AQUIND INTERCONNECTOR

Applicant's Responses to Deadline 6 Submissions – Hearings

Document Ref: 7.9.33

DATE: 25 JANUARY 2021

Plate 3.8 - Converter Station Parameter Plans (two options, Option B(i) Blue dash and Option B(ii) Green dash)

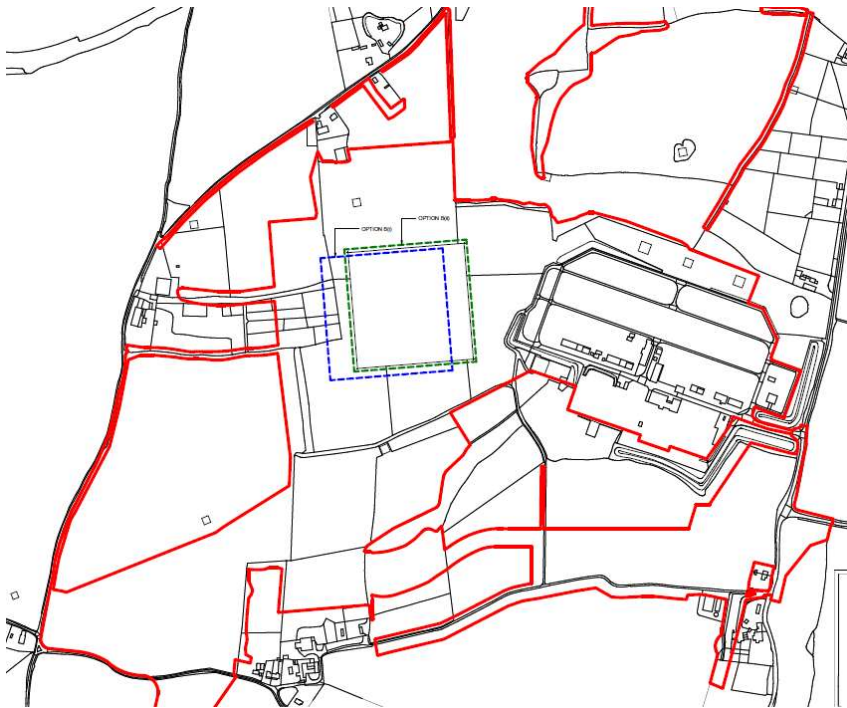
4.2	<p><i>Are all of the necessary parameters of the Proposed Development that require a 'Rochdale envelope' for the purposes of the EIA included in, and thus assured in the draft DCO? Are any parties aware of instances where this may not be the case? Are there two height options for the Converter Station as indicated in paragraph 5.2.4.3 of the Design and Access Statement and, if so, would there be any loss/ benefit of having the lower height secured in the dDCO?</i></p> <p>RT – In response to the contention of the applicant that the parameters are necessary to ensure that the subsequent procurement of contracts is OJEU compliant, counsel advised that this was not correct. As a matter of law, there would be no procurement impediment, if the DCO was so constrained re heights of building, which meant only one developer and/or only one engineering company could take the project, then only one could take the project. This is perfectly common in procurement and is provided for through OJEU compliant processes.</p>	<p>If the Undertaker is constrained on the height of the building, then this could lead to unfair advantages in the procurement process and would in effect prevent a competitive tender process. To ensure that no supplier, out of an already limited number of suppliers for this type of infrastructure, is not disadvantaged from offering their optimum solution the Applicant has sought to retain a range of potential building heights to accommodate suppliers' optimum equipment designs and roof designs.</p> <p>The impacts of the Proposed Development based on the maximum parameters applied for have been fully assessed.</p>

Para No.	Summary of Deadline 6 Submission	Applicant's Response at Deadline 7
	<p>4.2 (Variable Height to Converter Station Building)</p> <p>Winchester City Council notes the applicants explanation relating to the variation in the height of the equipment which is driving the request to maintain some flexibility in the height of the proposed converter station building. However, the Council notes the reference in the applicants explanation that the design of the roof will also play a role in the overall height of the building. If the choice to be made by the contractor comes down to one of a lower roof but at a higher cost, what weight is going to be given to minimising landscape impact in that decision process? How is the overall desire to bear down on height to be embedded in the final decision on building design?</p> <p>4.3 (Spare Capacity Fibre Optic Cable)</p> <p>Winchester City Council has made detailed representations on the Fibre Optic Cable (FOCs) issue in its local impact report and in its various submissions at the deadlines. The one aspect that we wish to raise is the applicants reluctance to offer an clear indication of the capacity that the two FOCs will offer. References to 192 fibres per cable and a 20-80 split between the Interconnector and commercial use has been offered but the question remains on how many lines that will actually be offered.</p> <p><i>Postscript: The Council notes the applicant's intention to offer a response on this matter by deadline 6.</i></p> <p><i>The Council recalls the conversation on whether the removal of the telecommunications building will necessitate a larger converter station to accommodate that element of the fibre optic cable link to be dedicated to the inter connector. The applicant indicated they would respond to this matter at deadline 6. The Council will await that response. However, it was understood that this split may already have been factored into the proposal as the telecom building is positioned outside the secure Converter Station area in anticipation that a commercial operator could obtain access to the FOC set up without the need to enter the energy site.</i></p>	<p>size of foundations and quantity of, quantity of cladding and cladding rails, insulation etc. With reference to Costing Steelwork #15 published in November 2020 (https://www.steelconstruction.info/images/a/a5/Costing_Steelwork-15.pdf), a 4m increase in the height of an industrial building (i.e. portal frame) can increase the construction cost by an average of about 15%. Therefore, it is in the contractor's interest to keep the building height as low as possible.</p> <p>4.3 (Spare Capacity Fibre Optic Cable)</p> <p>Please refer to the Applicant's post hearing notes submitted at Deadline 6 (REP6-063), paragraph 2.9.6 in relation to ISH1, which confirms it is anticipated that the FOC to be installed with each pair of DC cables will contain no more than sixteen (16) bundles of fibres, with each bundle containing twelve (12) fibres. Three (3) of these bundles are required for the essential operation of the interconnector and thirteen (13) bundles are available for commercial use. Thus the capacity split is 20% for essential use in connection with the safe operation of the Project and 80% for commercial telecommunications purposes.</p> <p>Further, paragraph 2.9.3 of the Applicant's post hearing notes submitted at Deadline 6 (REP6-063) in relation to ISH1 confirms the position with regard to the implications for the design of the Converter Station where the commercial use is not permitted and the Telecommunications Buildings removed. In those circumstances there would be no change to the control building design or dimensions.</p>

<p><u>Issue Specific Hearing 1 draft DCO</u></p> <p><u>Schedule 1, the Authorised Development</u></p>	<p>4.2 (Variable Height to Converter Station Building)</p> <p>The Applicant can confirm that the building height is a particularly important cost driver for industrial buildings of this nature and is always a key consideration during detailed design. The height of the building has direct impact on the overall cost of the construction as it will impact on the overall building frame weight,</p>

**Plate 6 - Proposed banksman locations - will be replaced with full page image when issued as PDF**

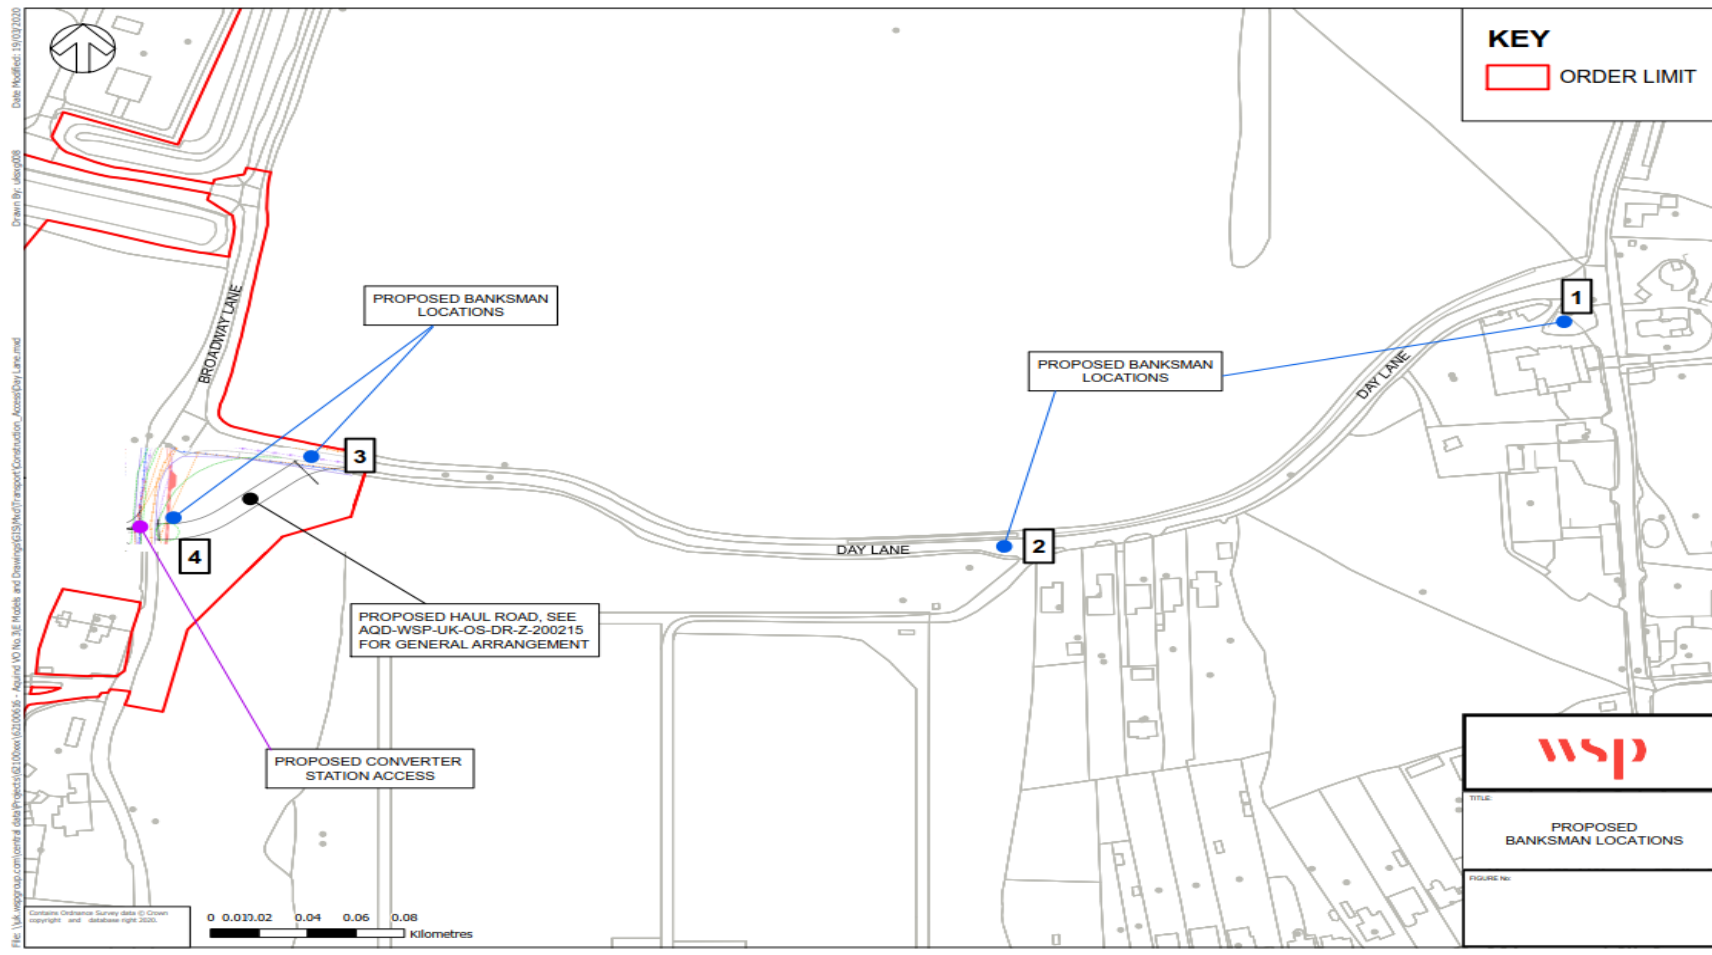
<p><u>General Matters</u></p> <p>The Highway Authority question the effectiveness of banksmen and whether they are legally able to control and direct HGV movements. Further clarification from the applicant is welcomed on this point.</p> <p>The applicant has not carried out a quantitative assessment of HGV travel time along Day Lane and how long the predicted number of HGVs will therefore spend on Day Lane based on the current controls. This assessment is required to understand the extent of the delays to existing road users resulting from the construction traffic movements.</p> <p>The applicant is required to address the points above before the construction traffic management strategy on Day Lane can be considered acceptable. Hampshire County Council would welcome further discussions with the applicant on any of the points raised within this note. The proposed control methods should also be subject to a Road Safety Audit.</p>	<p>The Applicant updated the FCTMP at Deadline 6 to refer to "marshal" instead of "banksman" following the comments raised at the hearings (REP6-033).</p> <p>Using an independent consultant, a Stage 1 Road Safety Audit has been completed on the proposed amendments to the junction of Day Lane / Broadway Lane, the proposed passing places on Day Lane which are set out within the Day Lane Technical Note (REP6-073), and the proposed methods of traffic control on Day Lane. The draft Stage 1 Road Safety Audit was issued to HCC on 20 January 2021.</p> <p>The Applicant is undertaking further discussions with HCC regarding their requirements for any accreditations for appointed traffic marshals, and is committed to complying with HCC requirements on this matter.</p>

Plate 6 - Proposed construction traffic management on Day Lane - will be replaced with full page image when issued as PDF

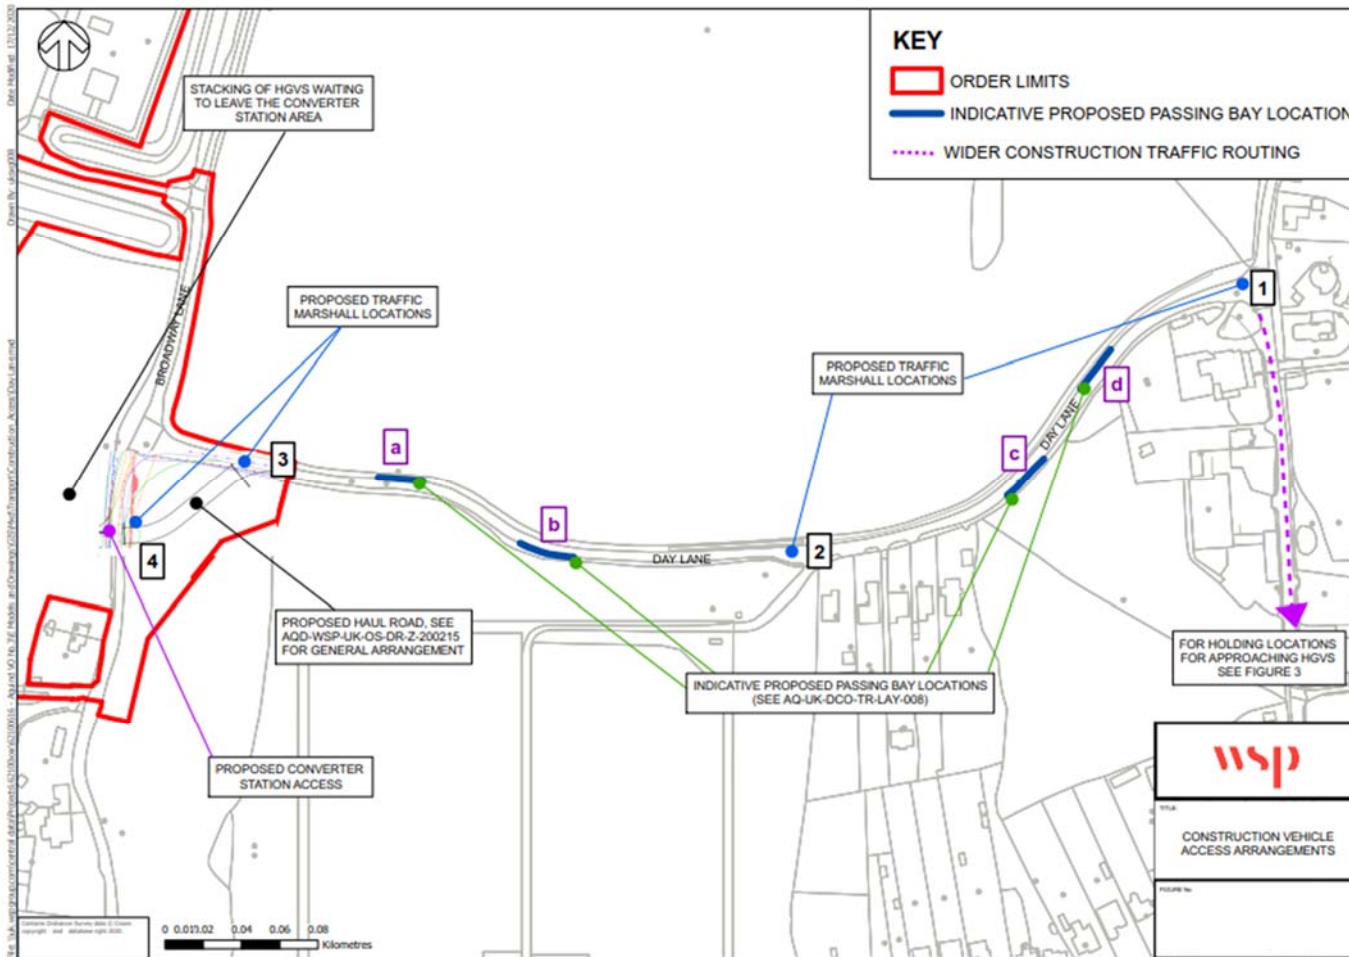
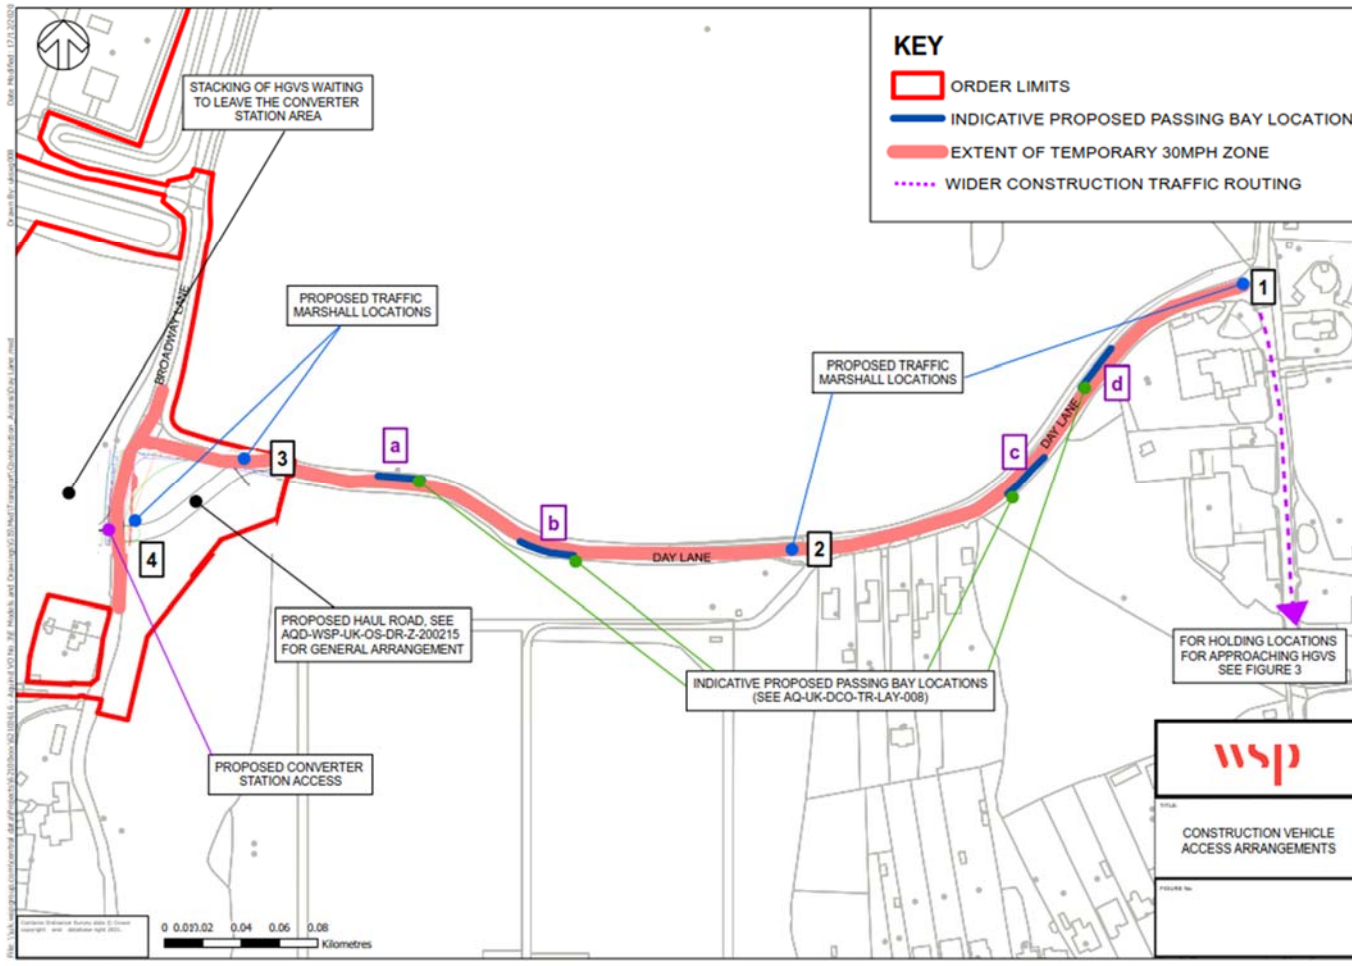
<p>Post Meeting Note Agenda Item 3d (point 4) – Operation of Day Lane</p>		
	<p>Within Hampshire County Council's (HCC) Deadline 3 and 5 responses to the AQUIND Interconnector DCO, concerns were raised regarding the traffic management strategy along Day Lane during the construction period of the works. Specifically, concerns were raised with the proposed banksmen control, the lack of passing places for a HGV and cars to pass, the safety implications of holding vehicles on carriageway at the Lovedean Lane/Day Lane junction and the overall delays to other road users as a result of the management strategy. Further to these responses, the Applicant submitted a revised traffic management strategy along Day Lane to HCC via email on Friday 11th December 2020 which had not been reviewed in detail prior to the ISH. The Highway Authority have subsequently reviewed the document and wish to make the following comments.</p> <p>Updated Strategy</p> <p><u>Arrivals</u></p>	<p>The Applicant has addressed this matter at Deadline 6 within the Day Lane Technical Note (REP6-073). Page 15 of the Technical Note includes details regarding been minor amendments which have been made to the location of the proposed traffic marshal to a new position on the Lovedean Lane arm of the junction with Day Lane. This is intended to mitigate concerns regarding vehicles turning into Day Lane and encountering stationary traffic. The proposed passing bays which are set out on pages 7-11 of the Technical Note address the concerns raised regarding the management of the meeting of HGV's and general traffic on Day Lane, and the management of residents' access on Day Lane is specifically addressed on Page 15 of the Technical Note. Attached to the Technical Note are drawings containing vehicular tracking undertaken of the proposed passing bays which demonstrate the ability of these bays to accommodate passing HGV traffic.</p> <p>Following discussions with HCC, it has been agreed between the Applicant and HCC that laybys at Hulbert Road, to the east of A3 (M) Junction 3 can be used as a waiting area for HGV's associated with the construction of the Converter Station. These laybys are existing HCC highway assets. HCC have confirmed that the northern layby can be used for this purpose and HGVs can be taken to the Converter Station construction site under escort. This will require the current ability of the travelling public to park at this facility to be temporarily suspended. This approach has also been discussed with Highways England who have confirmed it would allow their previous concerns to be resolved. The updated traffic management strategy</p>

Para No.	Summary of Deadline 6 Submission	Applicant's Response at Deadline 7
	<p>Following comments from the Highway Authority to take a more holistic approach towards the management of HGVs to and from the converter station, the applicant is now proposing a 'check in' system for all HGVs visiting the site. This will require the drivers to pre-book an arrival slot to the site with the banksmen positioned on Day Lane. To co-ordinate the timed arrivals, the applicant is proposing that the HGVs utilise a number of existing laybys on the strategic road network (SRN) located on the A27 and A3, as set out on Page 3 of the note.</p> <p>The applicant has not carried out any assessment to understand whether there is spare capacity at each of the identified laybys to accommodate HGVs throughout the construction period. Given that this matter relates to capacity along the SRN and appropriate use of the laybys, Highways England will need to confirm whether they are happy with the principle of these laybys being used and should be formally consulted on the note.</p> <p>HGVs arriving to the site will still be held on carriageway at the junction with Lovedean Lane/Day Lane. The Highway Authority remain concerned with this arrangement and the potential for accidents to occur if a vehicle turning into the junction fails to anticipate the stationary traffic. The applicant is therefore requested to investigate whether any waiting facilities can be provided off the highway, as noted within previous written representation.</p> <p>The Highway Authority remain concerned with the delays resulting from the current inability to convoy HGVs into the site. The 'check-in' system will better inform the banksmen of incoming HGV movements and therefore prepare them to hold eastbound HGV movements along Day Lane and remove this element of conflict and management of 2 HGVs meeting on Day Lane itself. However, the majority of Day Lane is of insufficient width to allow a car to pass a HGV. It is not clear how management of general traffic is to be undertaken when the HGV is on route to the site at the Broadway Lane end of Day Lane. If the HGV must arrive at the Lovedean Lane/Day Lane junction before general traffic can be held then safety issues still remain on how this is to be accommodated on the highway network. As the holding areas are circa 20 minutes away from the junction it would be inappropriate to hold traffic until the HGV arrived. The proposed management system also still means that arrivals of HGV's will take place in a piecemeal manner, creating delays for existing users of Day Lane. As mentioned within the latest note, it is anticipated that there will be 6 westbound and 6 eastbound HGV movements per hour during construction of the converter station. The Highway Authority therefore remain concerned that the lack of regulation of incoming HGVs will cause significant delay for road users on Day Lane who are held to allow for HGV movements. The applicant has also not commented on how movements in between banksmen i.e. residents with</p>	<p>for Day Lane has been included in an updated version of the Day Lane Technical Note (REP6-073). The updated Day Lane Technical Note has been submitted at Deadline 7 (REP6-073, Rev002).</p>

Para No.	Summary of Deadline 6 Submission	Applicant's Response at Deadline 7
	<p>access to their properties via Day Lane will be managed whilst westbound HGV movements are being undertaken. Given the lack of passing places available on Day Lane, the movement of these vehicles should also be controlled to ensure that they do not conflict with the HGV management strategy.</p>	
	<p><u>Departures</u></p> <p>To manage the movements of HGVs along Day Lane, the applicant has also proposed a convoy system for lorry's departing the site to reduce the period which departing HGV's occupy Day Lane. This would involve HGVs being held within the site on the new haul road until there are 3 vehicles ready to head eastbound along Day Lane. At this point, the banksmen will communicate to prevent any further oncoming traffic travelling along Day Lane, allowing the HGVs to be released in one go. This system offers an improvement over the previous strategy which allowed for HGVs to come and go freely (albeit still under banksmen control). There are no details of where it is proposed to hold vehicles waiting at the Day Lane/Lovedean Lane junction or how any movements from the properties along Day Lane will be controlled. There are safety concerns regarding the holding of traffic at the junction as a result of an unexpected queue on the carriageway. This needs to be understood further and measures considered to ensure that any queue does not create a safety issue. Further information is sought on these matters.</p>	<p>The Applicant has addressed this matter at Deadline 6 within the Day Lane Technical Note (REP6-073). Page 15 of the Technical Note includes details regarding minor amendments which have been made to the location of the proposed traffic marshal to a new position on the Lovedean Lane arm of the junction with Day Lane. This is intended to mitigate concerns regarding vehicles turning into Day Lane and encountering stationary traffic.</p> <p>The updated traffic management strategy for Day Lane has been included in an updated version of the Day Lane Technical Note (REP6-073). The updated Day Lane Technical Note has been submitted at Deadline 7 (REP6-073, Rev002). This includes a capacity assessment of the operation of the use of STOP/GO boards at the junction of Day Lane / Lovedean Lane during the limited time each hour that HGVs will be departing the Converter Station. This shows forecast queues on each approach of Lovedean Lane of no more than five vehicles at the time when the STOP/GO Boards are used to manage outbound HGVs. This does not reflect an adverse highway safety position and no comment concerning queuing traffic at this junction was raised by the Stage 1 Road Safety Audit. The Applicant is of the view that this matter will be resolved in advance of the end of the Examination.</p>
